CITY OF PORTLAND

November 23, 1992

RE: 75 Douglass St.

Your application to demolish garage and rebuild on same footprint, has been reviewed and a permit is herewith issued subject to the following requirements:

Douglass Street

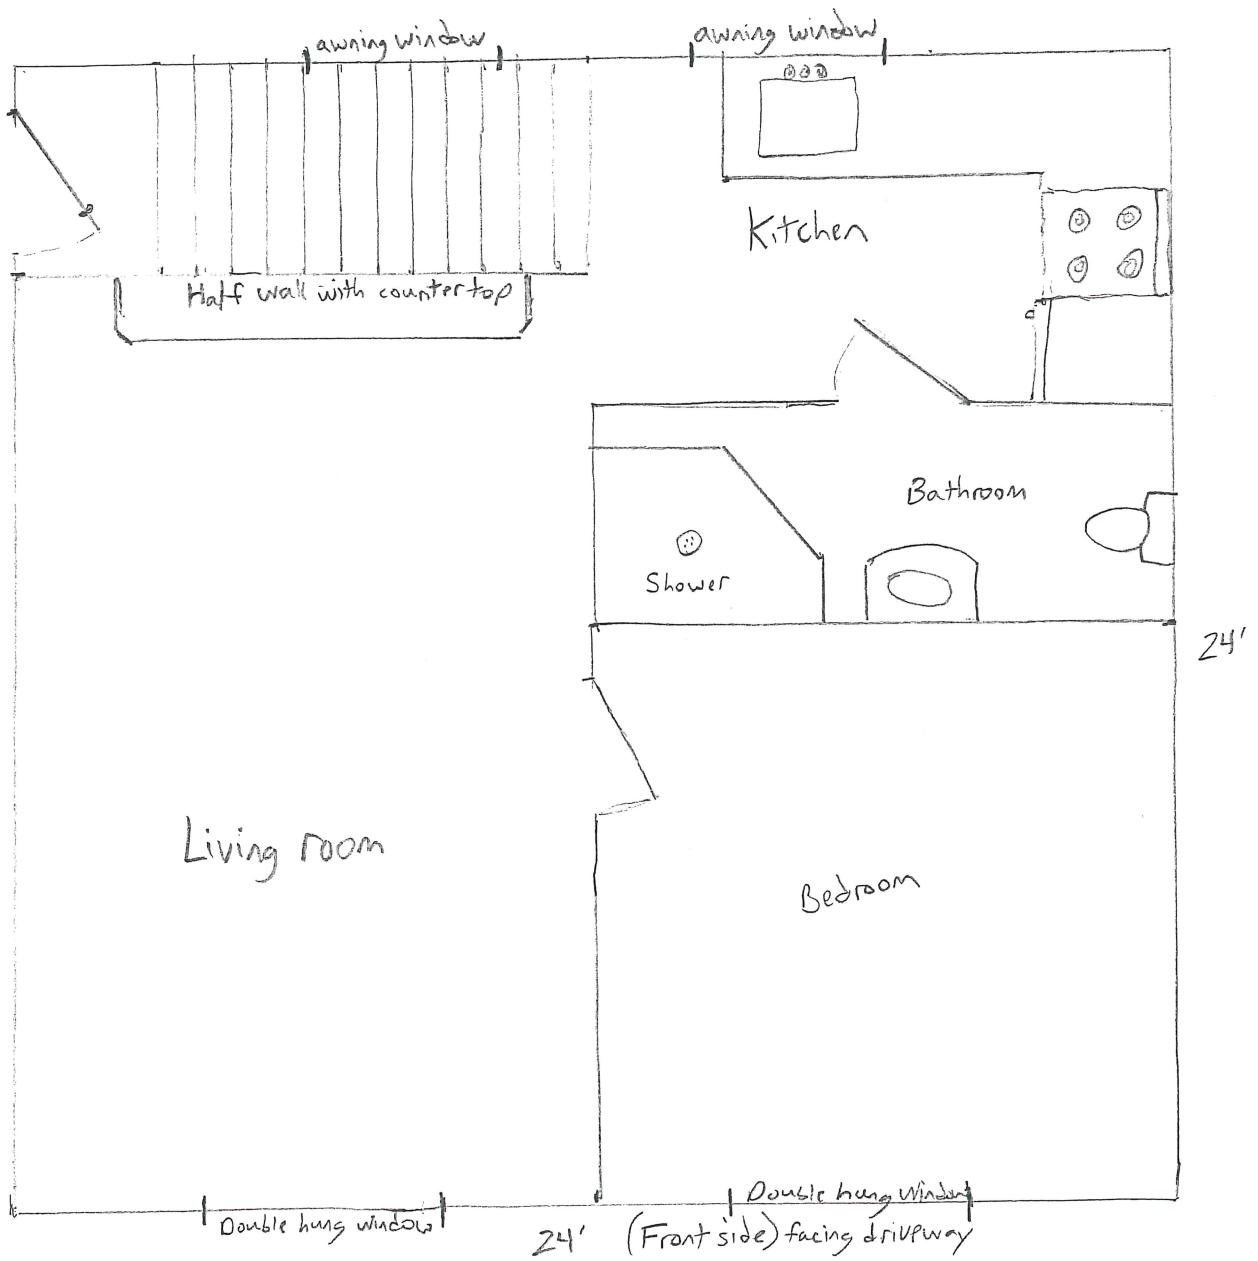
1. This permit is being issued with the understanding that the proposed structure does not encroach any closer to side lot line. The expansion of the garage in width will take place on the inward side of your yard, not the outboard.
2. The length expansion will be in the front of the proposed garage not the rear.
3. As you stated, the existing garage was not 18' X 20" as permit stated but was 19' X 23" and it was built in 1949.
4. Please read and implement items 1, 2, and 15 of the attached building permit report.
